Please ask for: Nicola Moore  
Email: [nicola.moore@arun.gov.uk](mailto:nicola.moore@arun.gov.uk)  
Telephone: Ext 37944  
Our Ref: A/109/21/L  
Your Ref:  
Date: 7th June 2021

**Listed Building Consent for Alterations, Extension or Demolition of a Listed Building**

**Development:** Listed building consent for the replacement of 5 No. windows on front elevation and rebuild of flint boundary wall.  
**Location:** Church House Arundel Road Angmering BN16 4JS

Site Plan, Church House, Arundel Road, Angmering, BN16 4JS

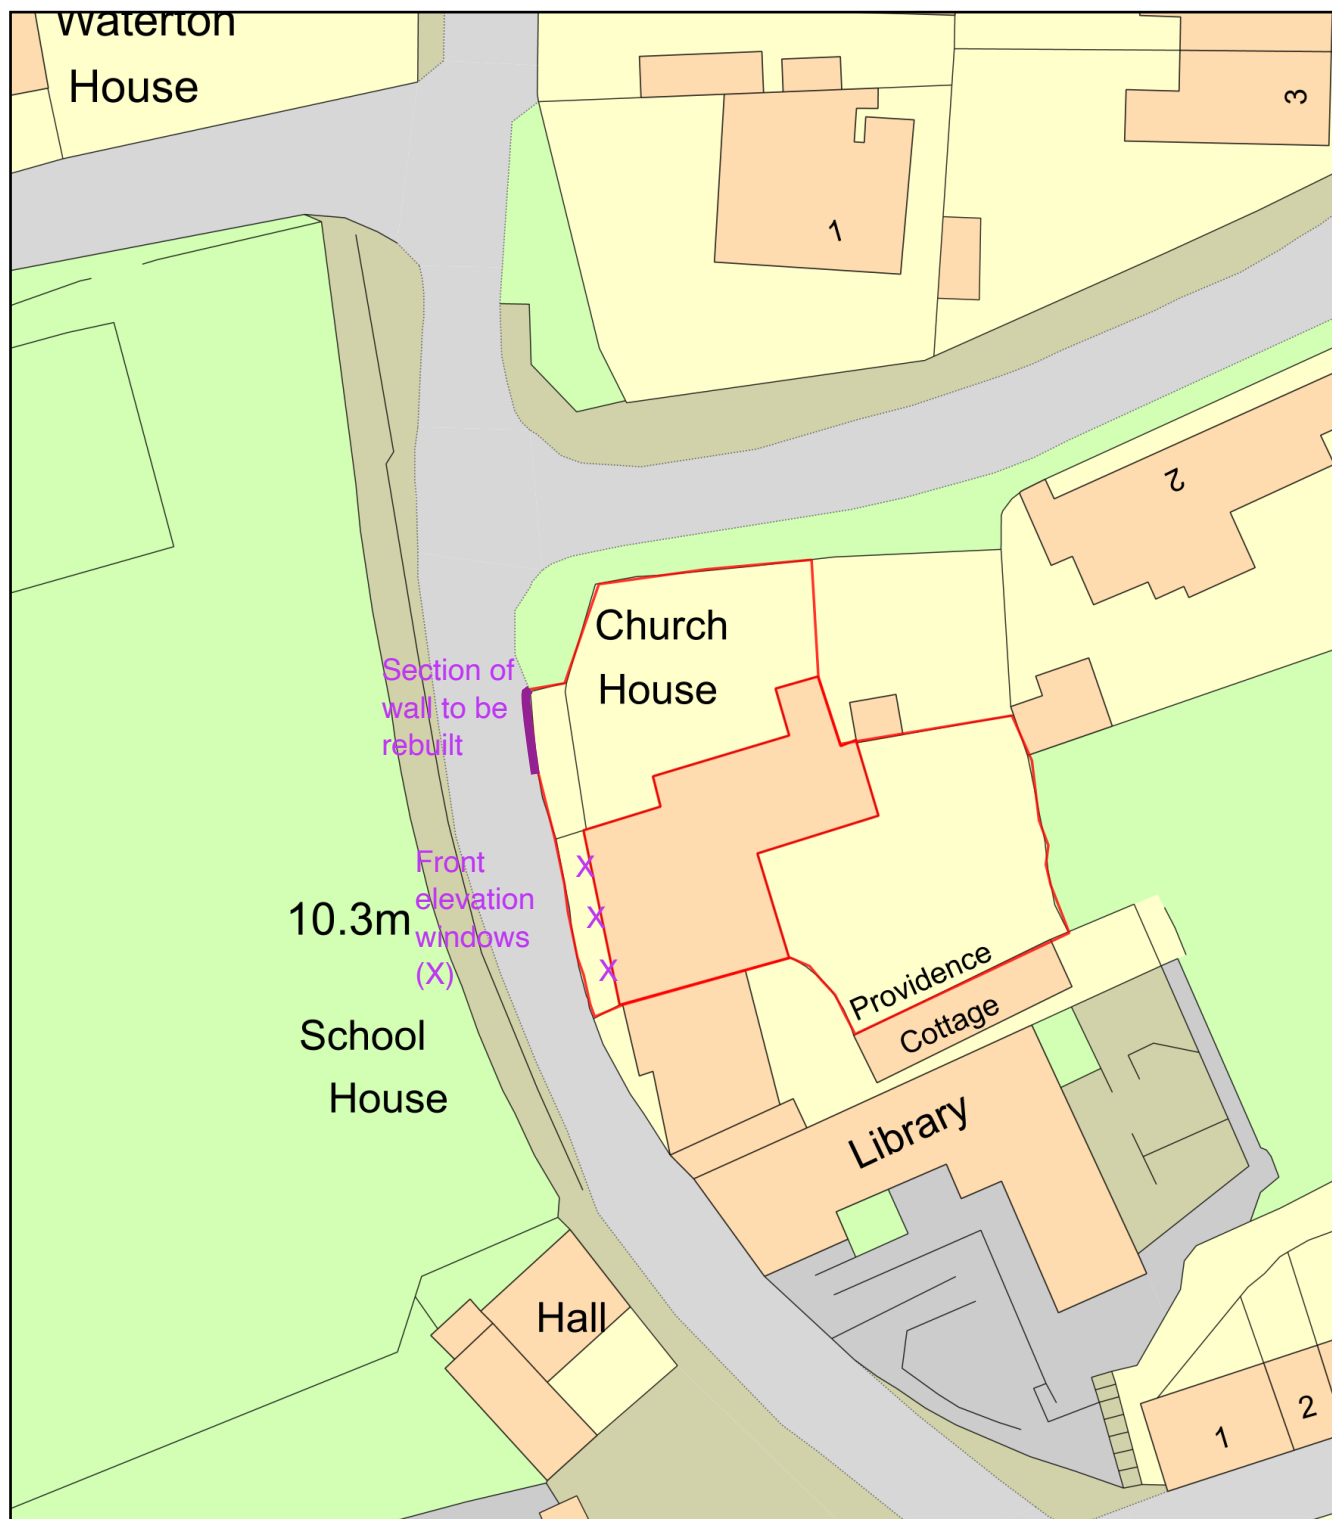
Please amend the submitted Block Plan to clearly indicate the proposed works. This can be hatched, colour or bold line to show the windows and wall.
